From: Liz Annalls [REDACTED]
Sent: 17 June 2020 11:32
To: Planning.Responses <Planning.Responses@arun.gov.uk>
Subject: RE: Planning Consultation on: A/86/20/DOC

App No: A/86/20/DOC
Address: Manor Nursery High Street Angmering BN16 4AW
Proposal: Approval of details reserved by condition imposed under ref A/51/14/OUT relating to Condition Nos 4 - materials & finishes, 5 - retained trees, 6 - surface water drainage, 7 - car parking 9 - roads, footways & casual parking areas, 10 - Construction Management Plan, 11 - Travel Plan, 12 - archaeological, 13 - ecology, 14 - broadband, 19 - foul water sewerage disposal, 20 - public water supply, 21 - surface water drainage, 22 - SuDs, 23 - refuse & recycling bins, 24 - contamination, 29 - pedestrian & cycle linkages & vehicular access and 30 - materials & finishes

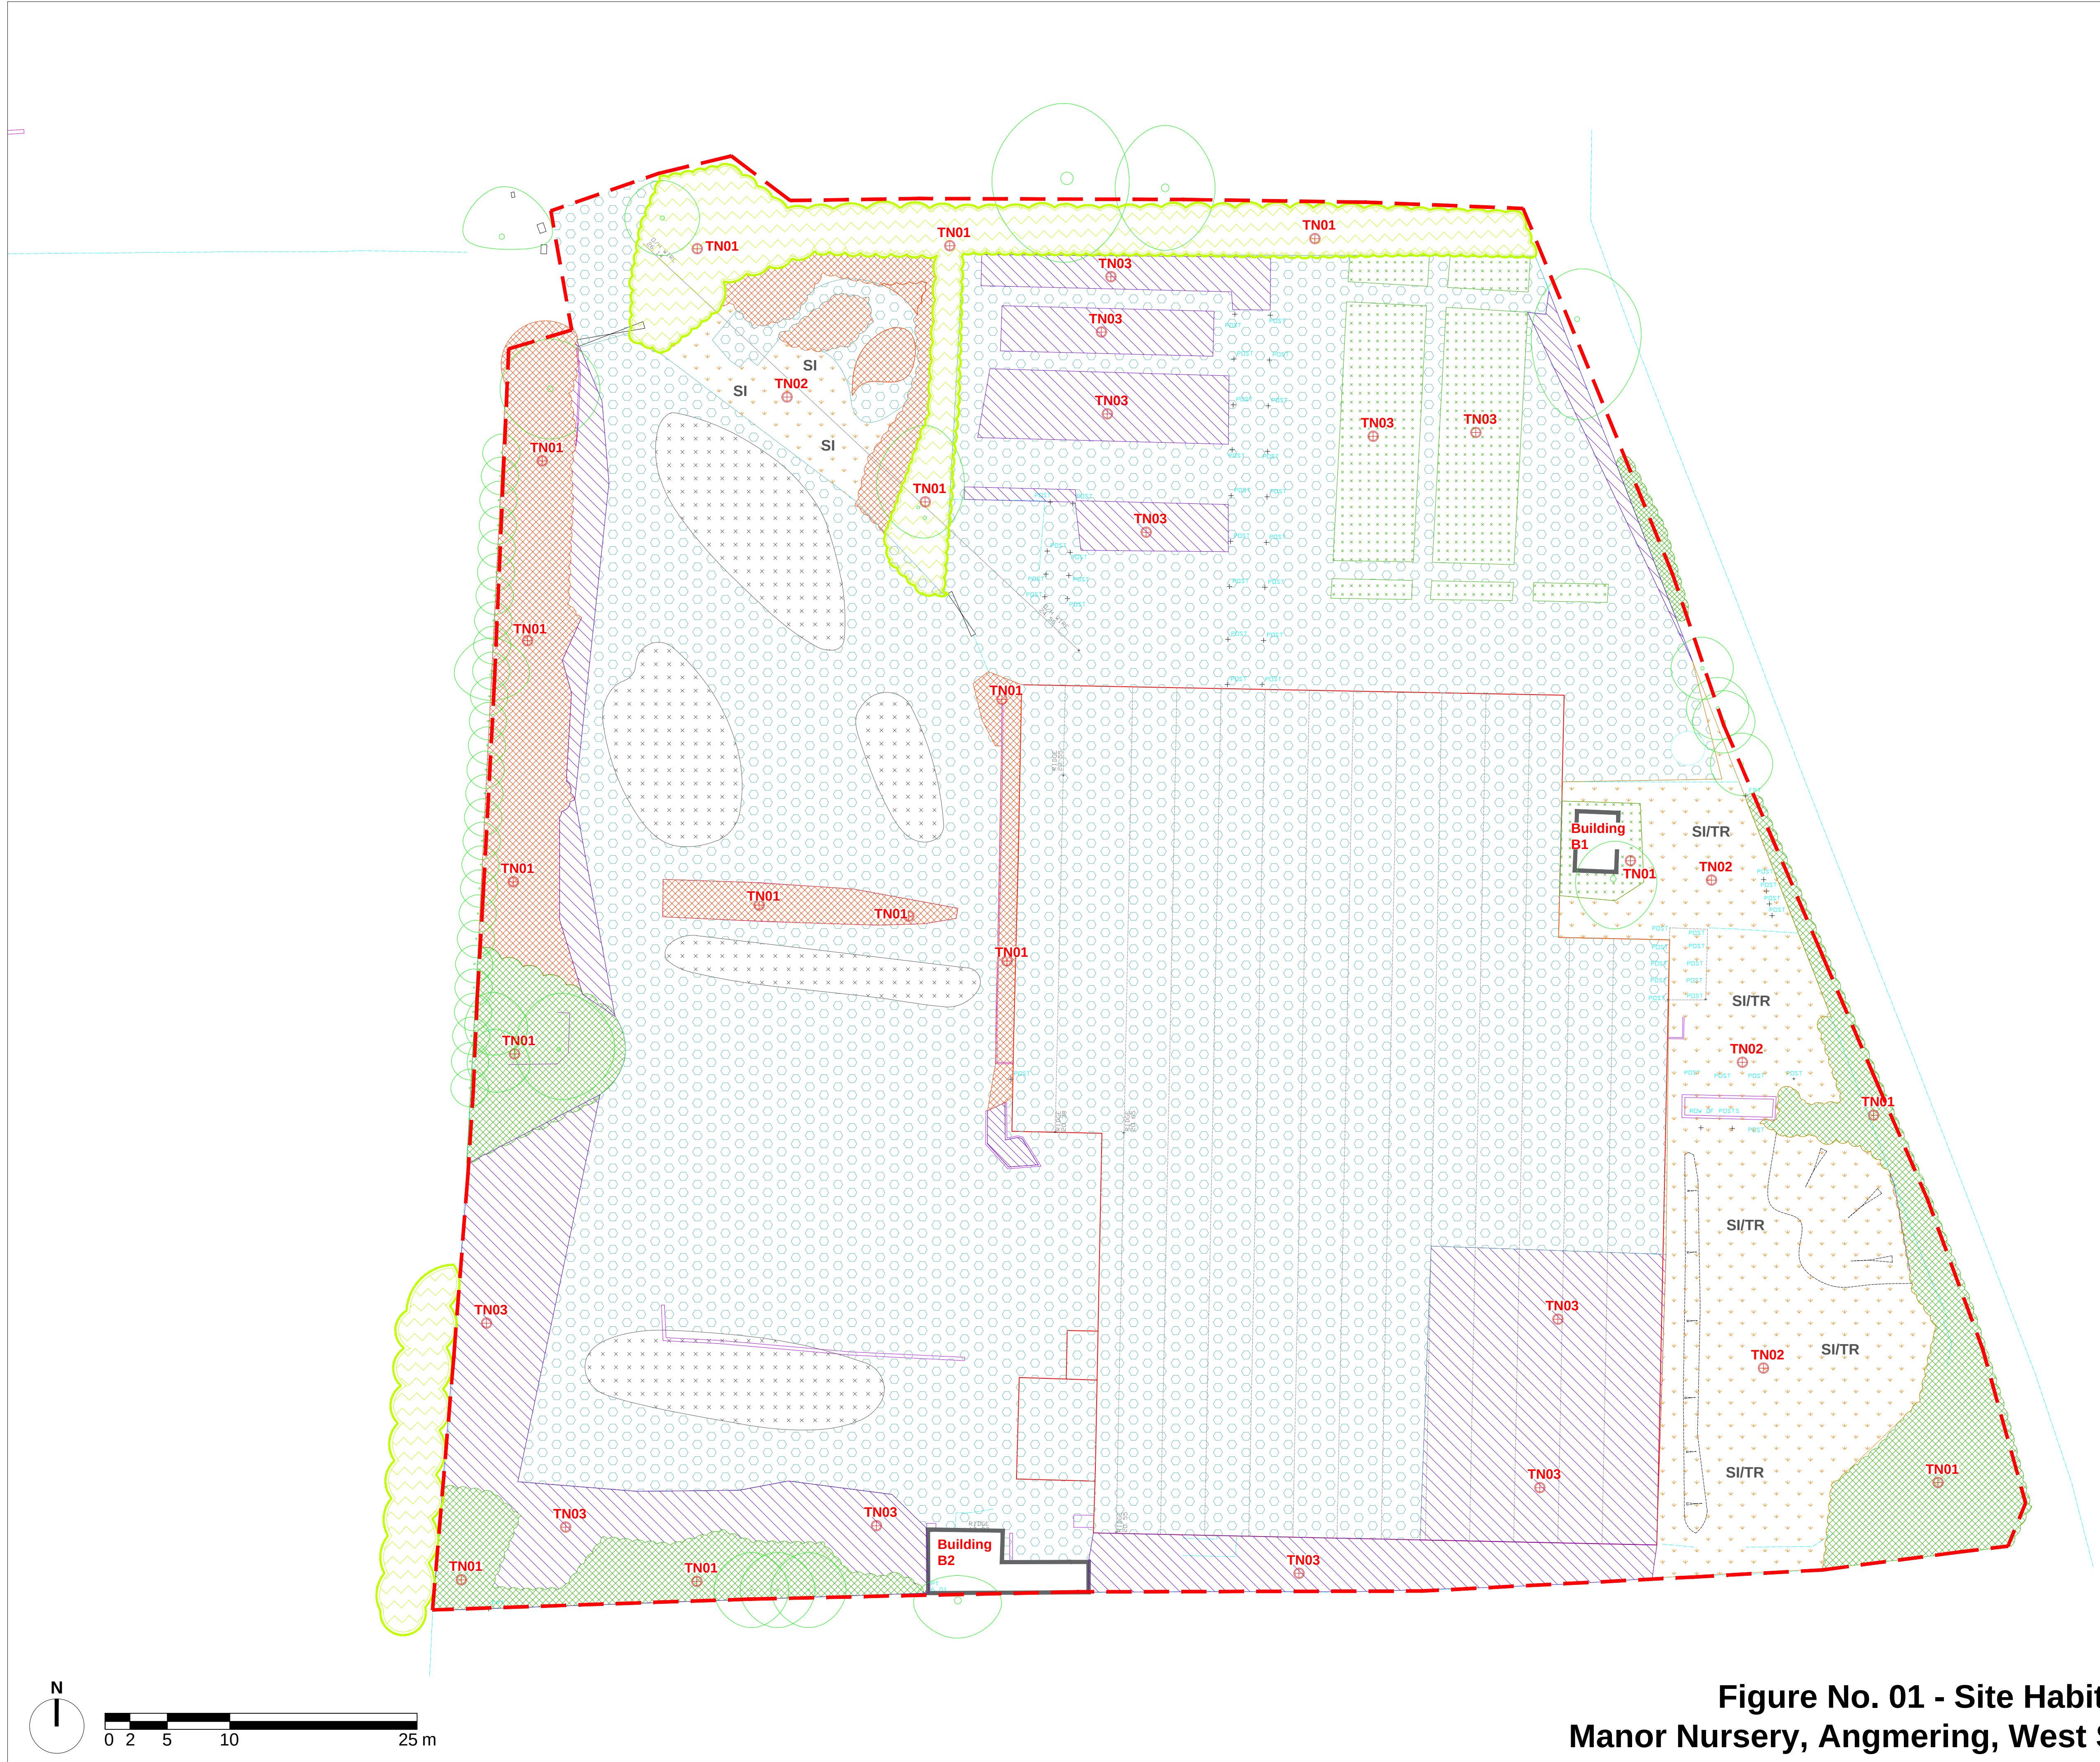
Though the following documents – Preliminary Ecological Appraisal Survey Report (Oct 2017), Reptile Presence and Absence Survey Report (Oct 2017) and Site Habitat Plan (Oct 2017) have been submitted as part of the DOC application there is a lack of information relating to the mitigation and enhancements which will be taking place on

the site. Though the Preliminary Ecological Appraisal Survey Report (Oct 2017) provides a list of enhancements which could be incorporated into the proposal, there is no plan showing how these have been incorporated. Please can the application provide further information relating to this. Including,

- Location and numbers of bat and bird boxes onsite, and what type of boxes will be installed
- List of native plant species being used
- Where hedgerow and trees are being incorporated into the scheme
- How will the lighting scheme incorporate bat sensitive lighting within it
